Traffic Impact Study (TIS) – Traffic Memorandum

16888 Elbert Road (Parcel 4122000002) – Special Uses

Revision 5

## Site Plan

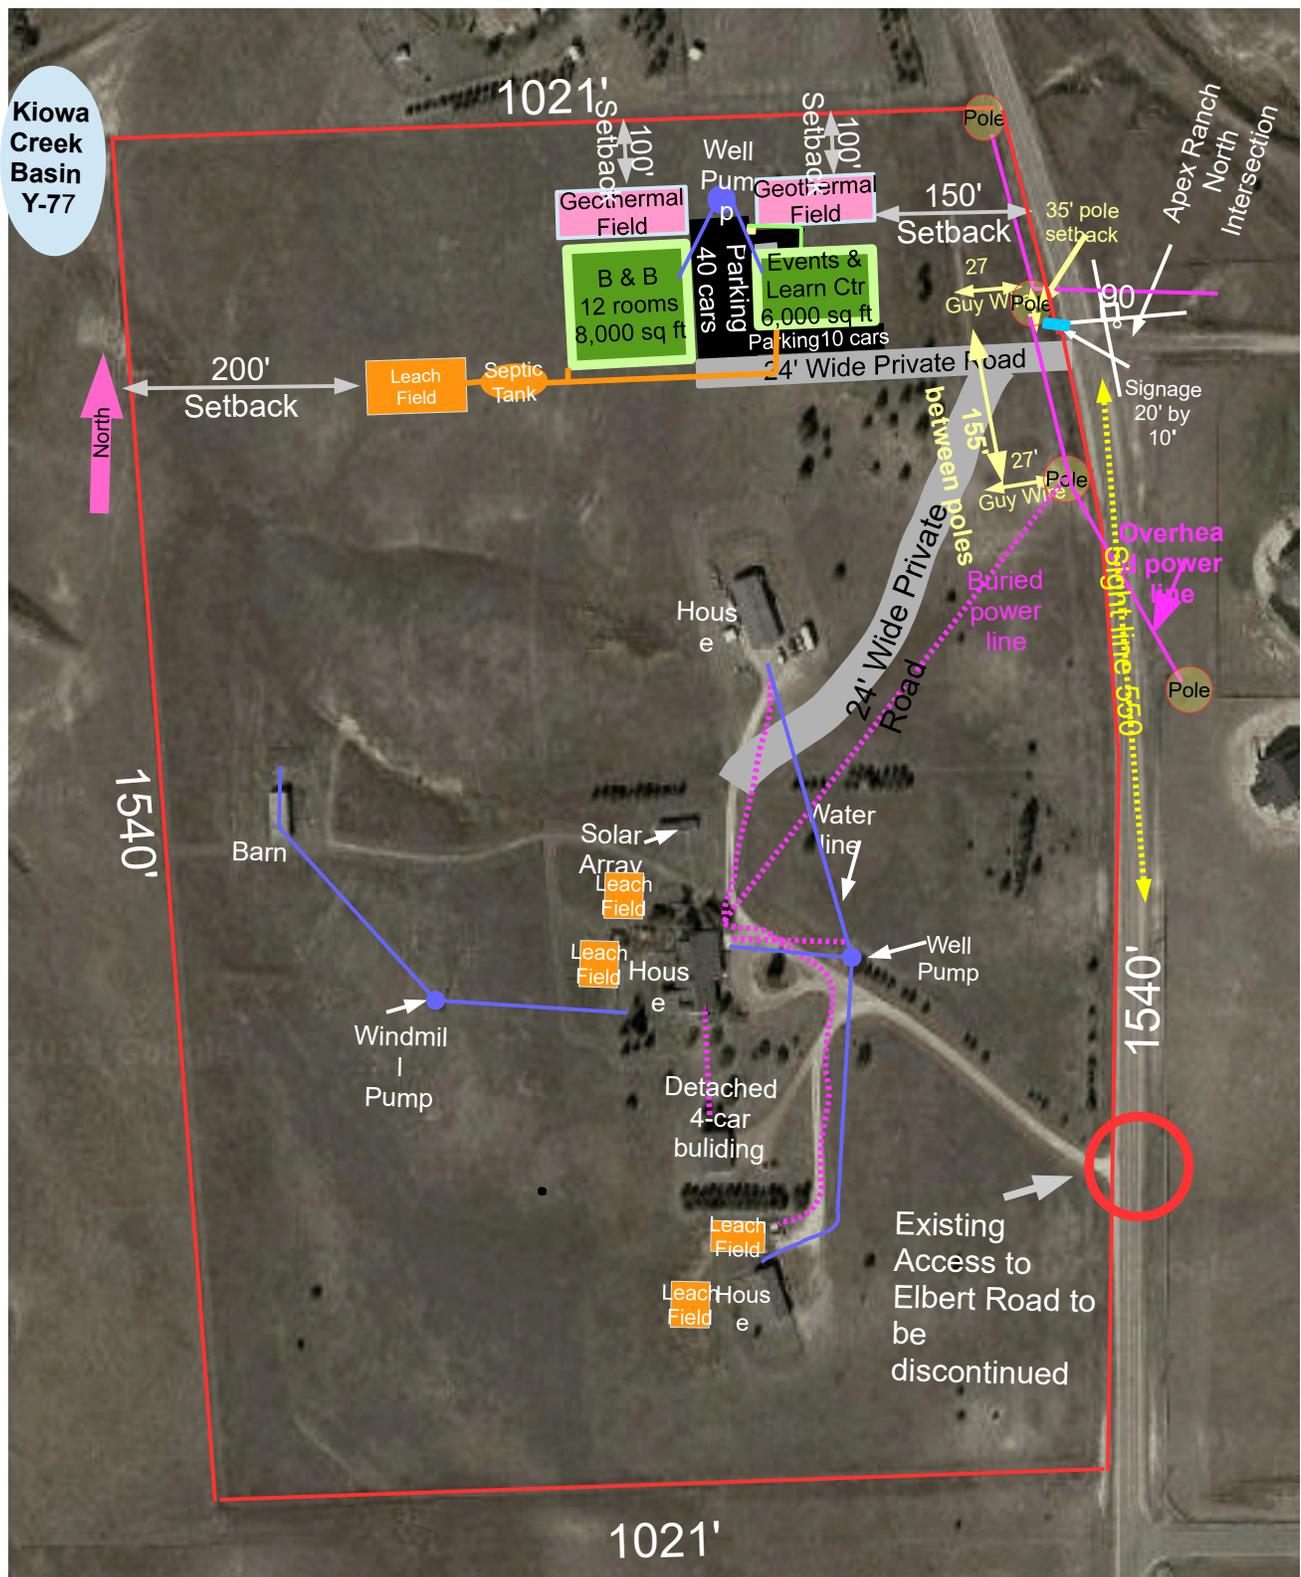
Site plan shows 3

# Weekend Days Noon Average Hourly Traffic Flow for Intersections

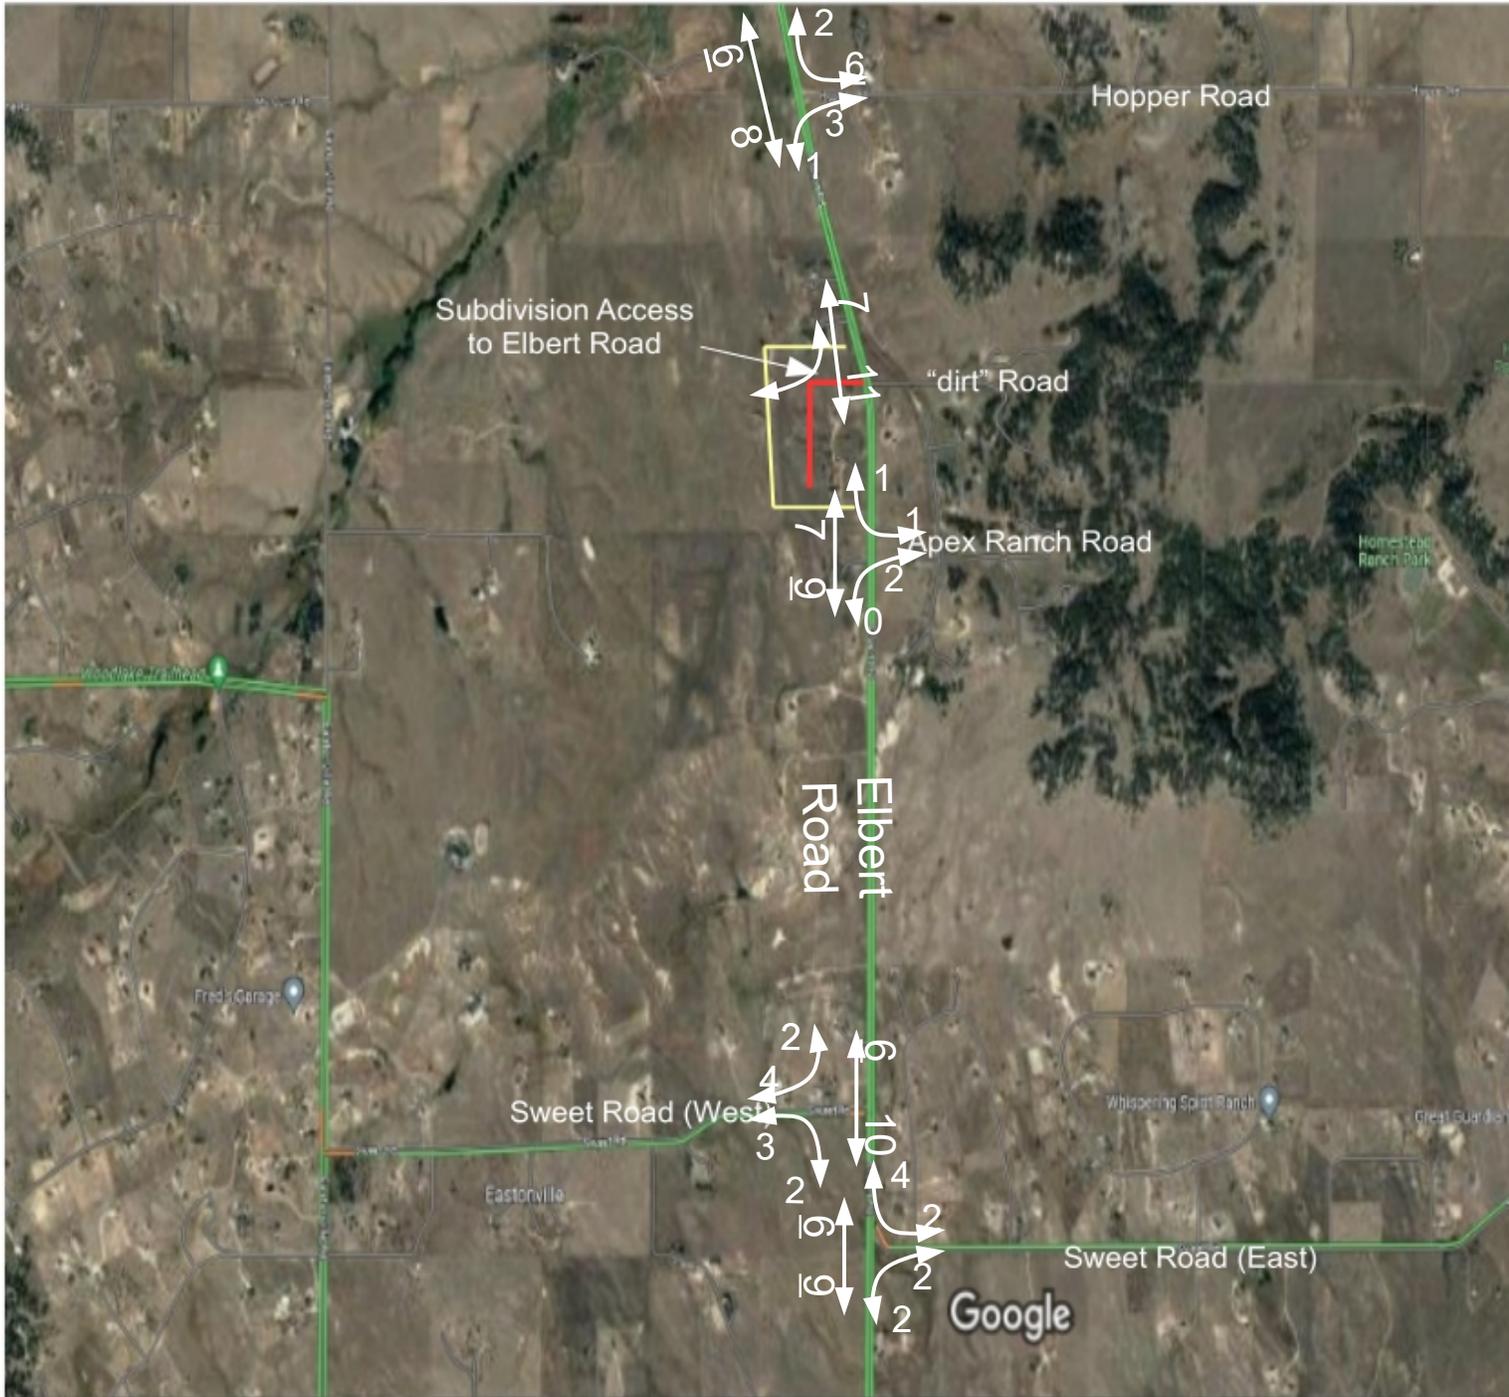
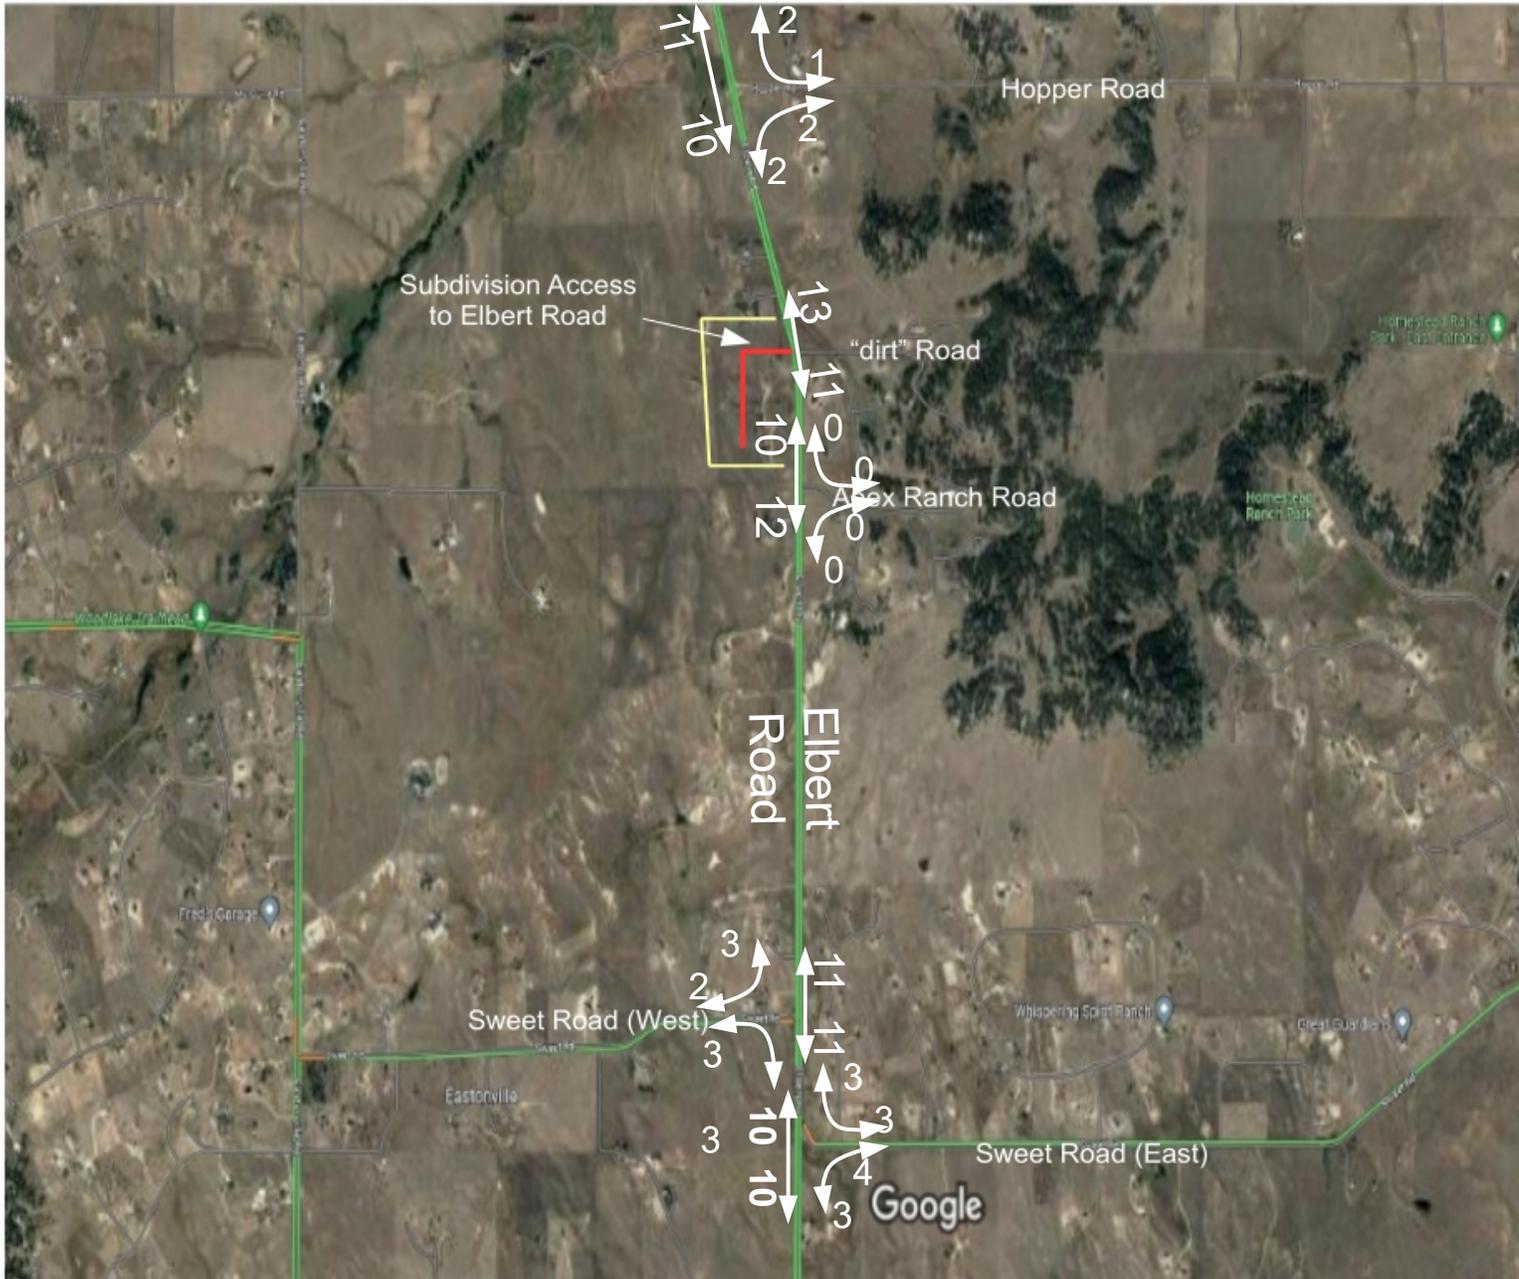
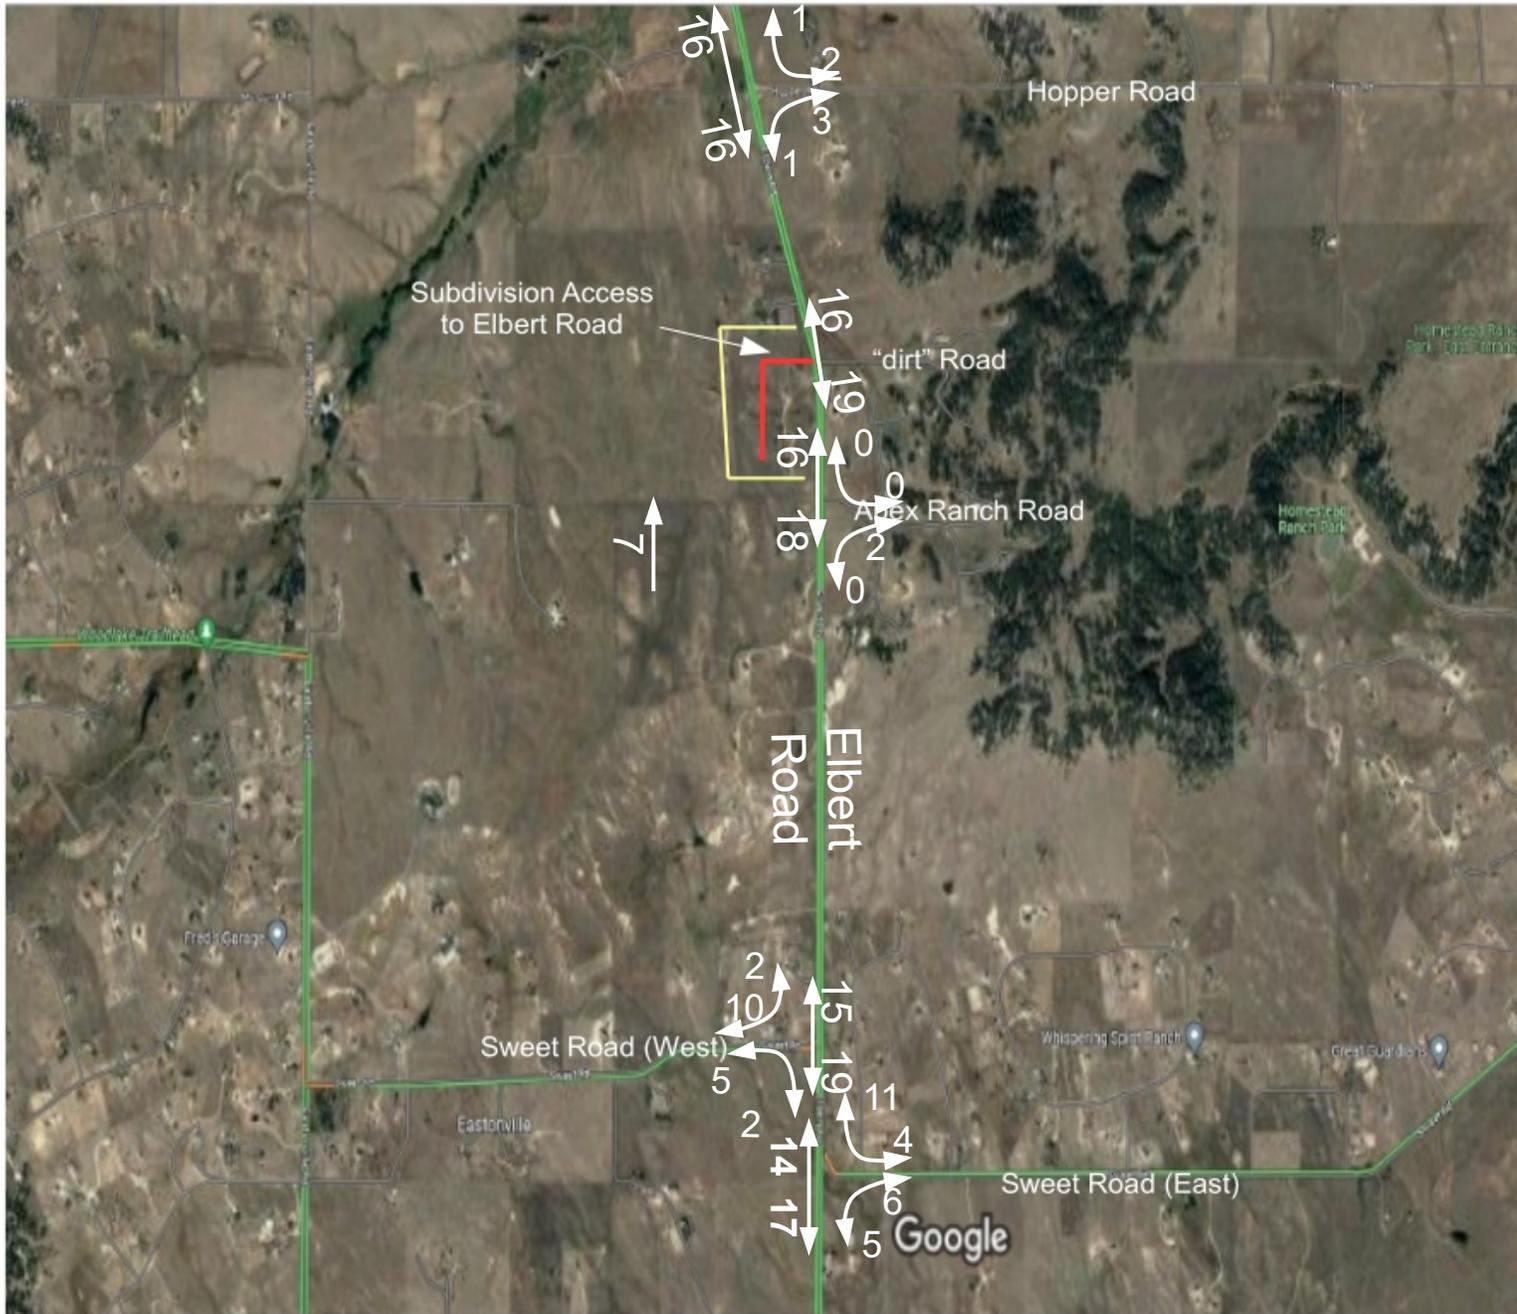
Label all maps as existing, short term and long term.

Add legend to all and update ADT and peak hr for all
